DEVELOPMENT REVIEW BOARD - **HYDROLOGY SECTION**
Dana Peterson PE., 924-3695, dpeterson@cabq.gov

DRB Project Number: 2019-002184 Hearing Date: 12-18-2019
Project: Guardian Storage Juan Tabo & Osuna Agenda Item No: 1

SHEET TITLE: CONCEPTUAL DRAINAGE PLAN

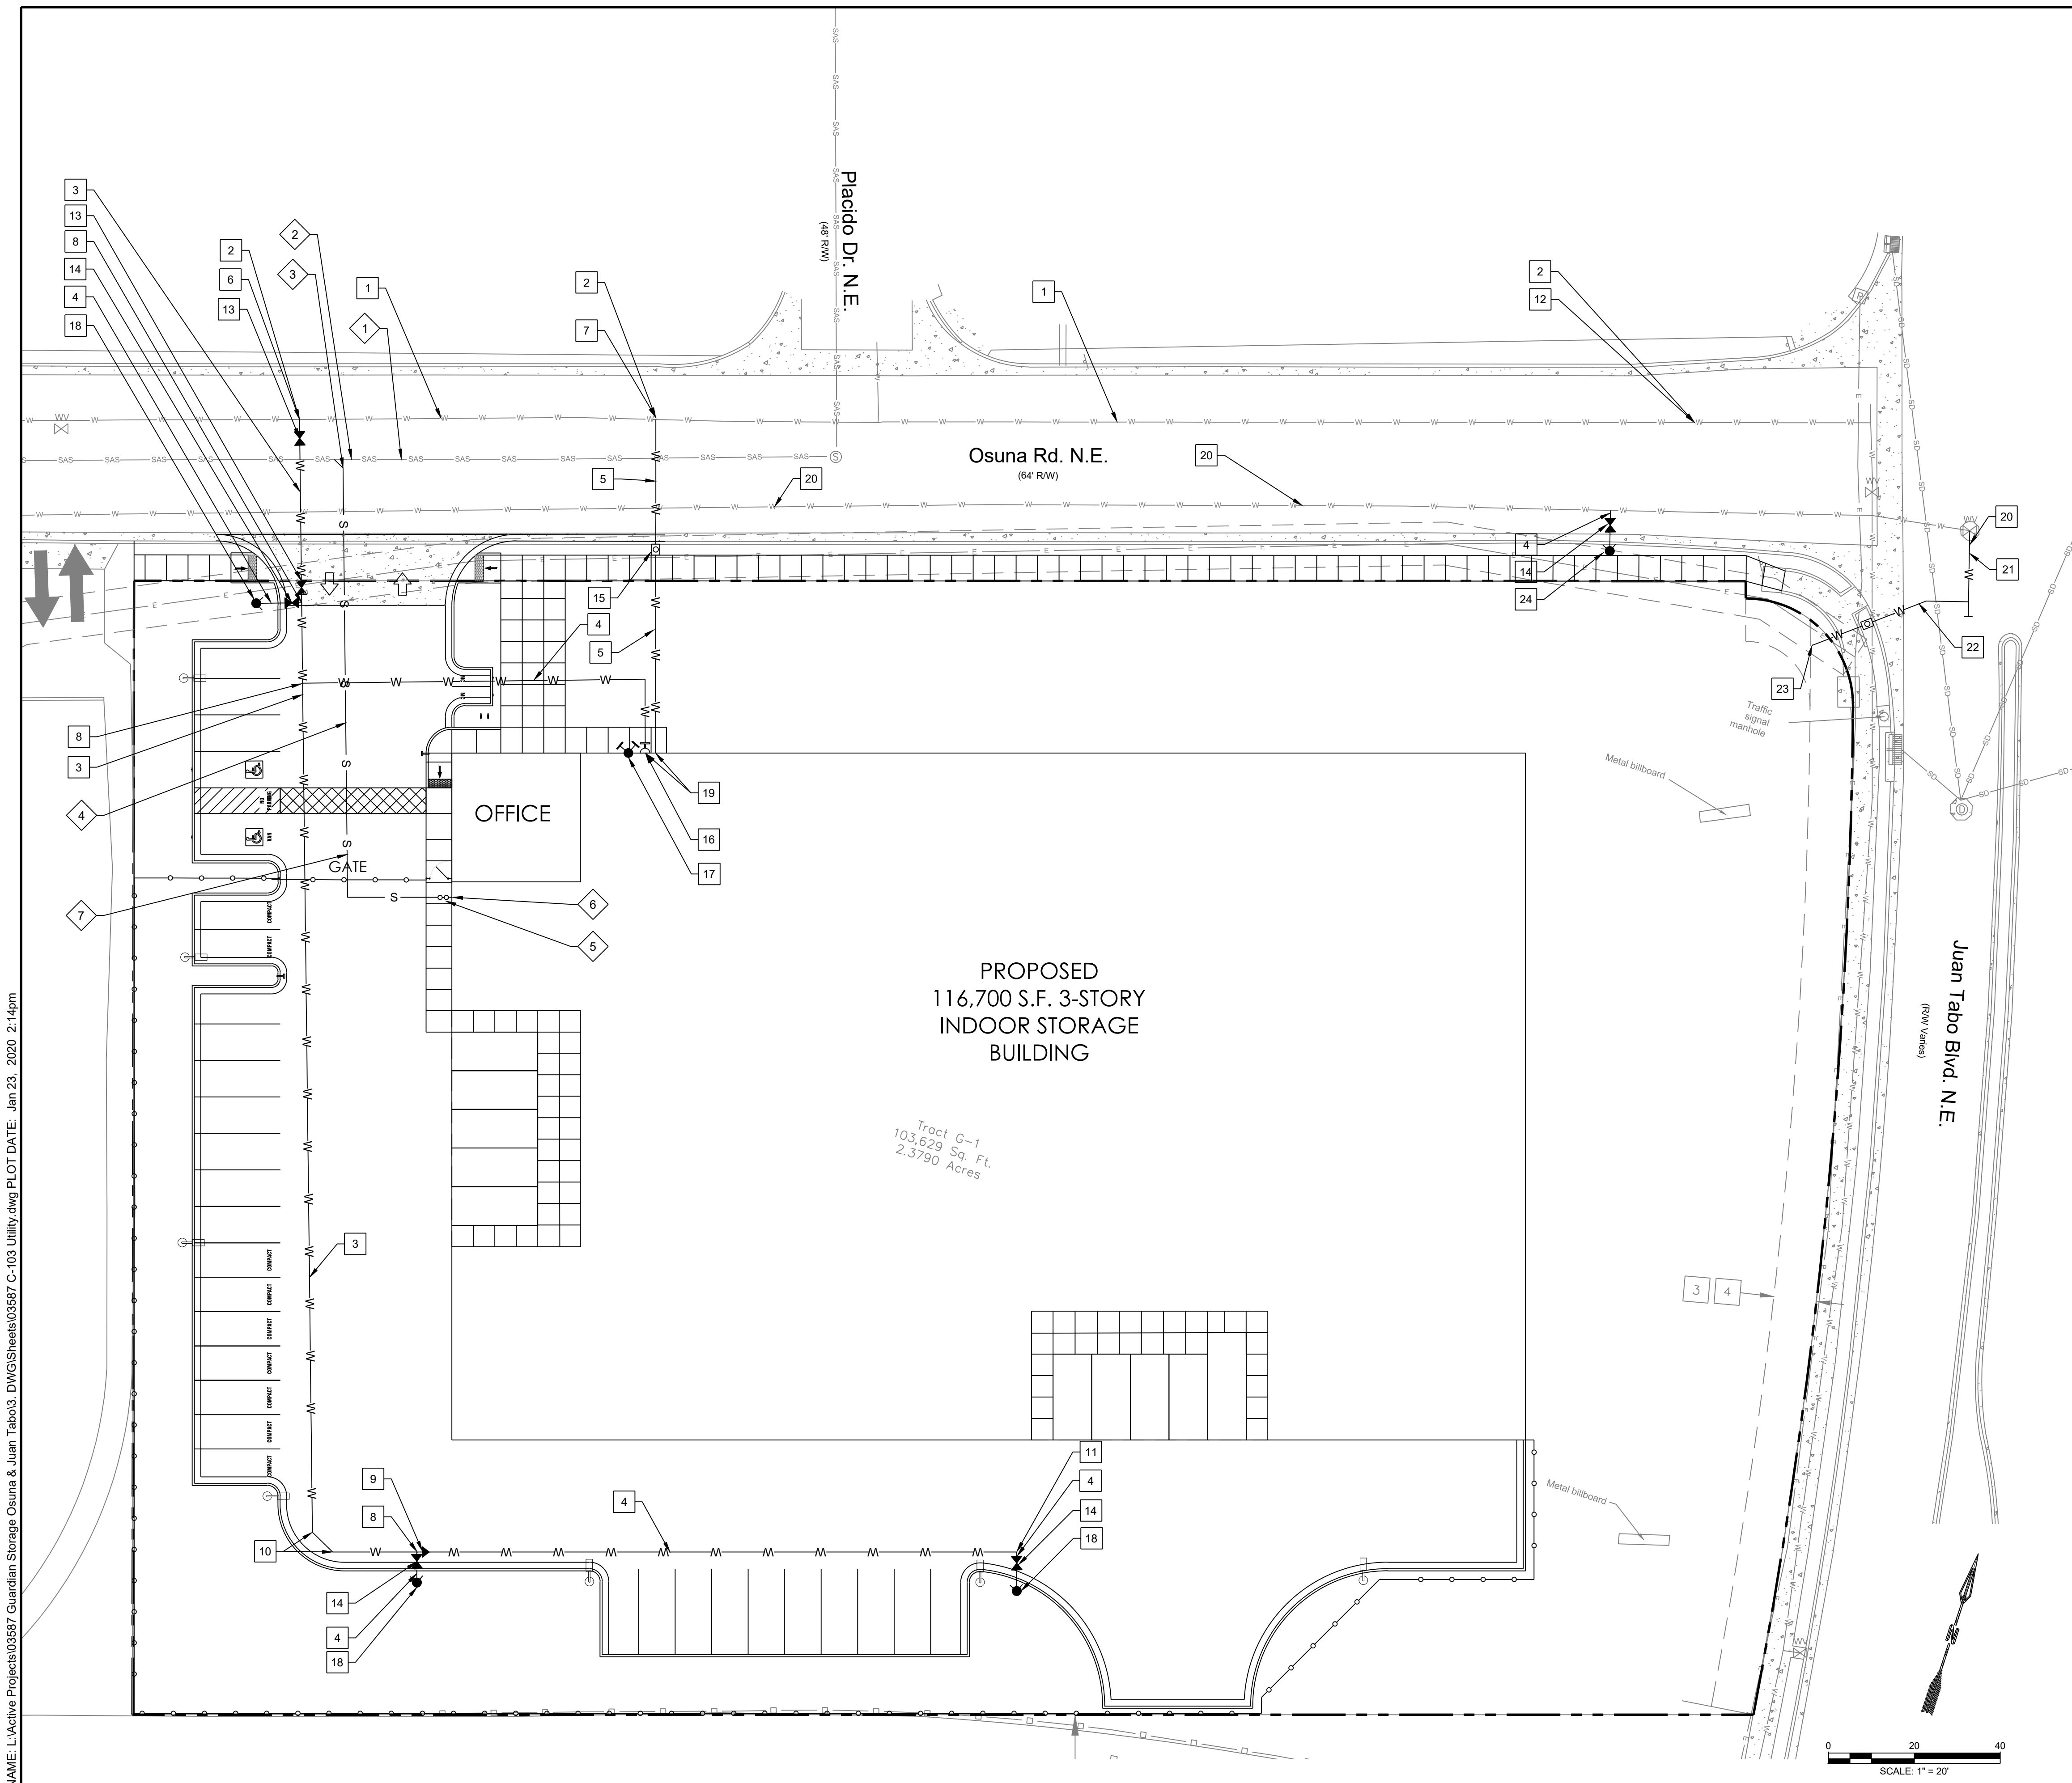
- An approved conceptual grading and drainage plan is required.
- The pipe penetration into Bear Canyon Arroyo needs to be on the Infrastructure List
